Consultation Response from KC, Highways Development Management
2025/90890 Land at, Yew Tree Road, Birchencliffe, Huddersfield, HD2 2EQ
Variation of conditions 1 (Plans), 2 (Materials), 6 (Landscape Works). 7 (Landscape Management Plan), and 14 (Ecological Design Strategy) of previous permission 2021/94363 for reserved matters application pursuant to outline permission 2018/90151 for erection of 17 dwellings
Date Responded: 14-7-2025 Responding Officer: Mark Berry. Responding Ref: 4-1-50.

The section 38 team have been consulted regarding these revised proposals. Their comments are as follows.

Refuse lorry - East to west

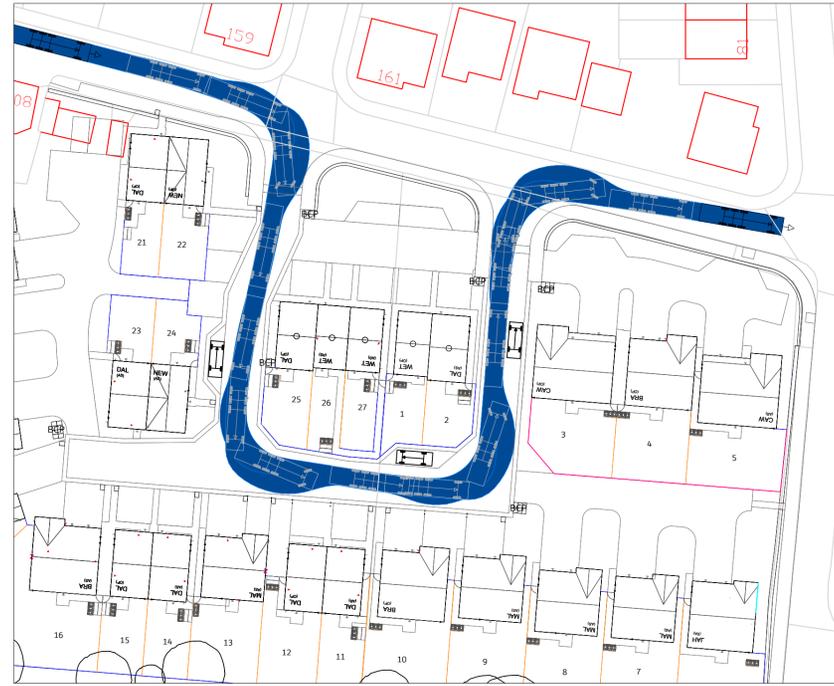
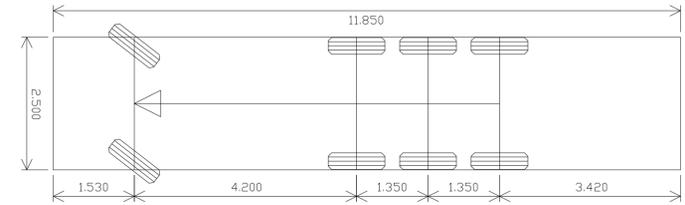
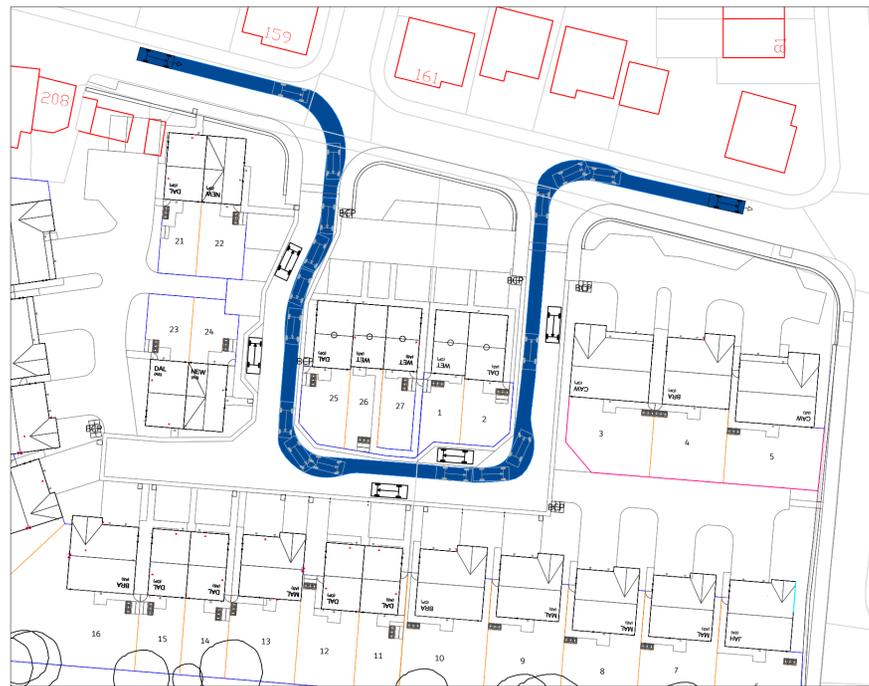
Kirklees require a swept path analysis for an 11.85m in length refuse vehicle indicating how it can pass an on-coming or parked family car throughout the layout. The carriageway will require widening on the bends to enable this manoeuvre. The refuse lorry below does not indicate how it can pass an on-coming car in the areas circled red below which is not acceptable and hence the carriageway will require widening.
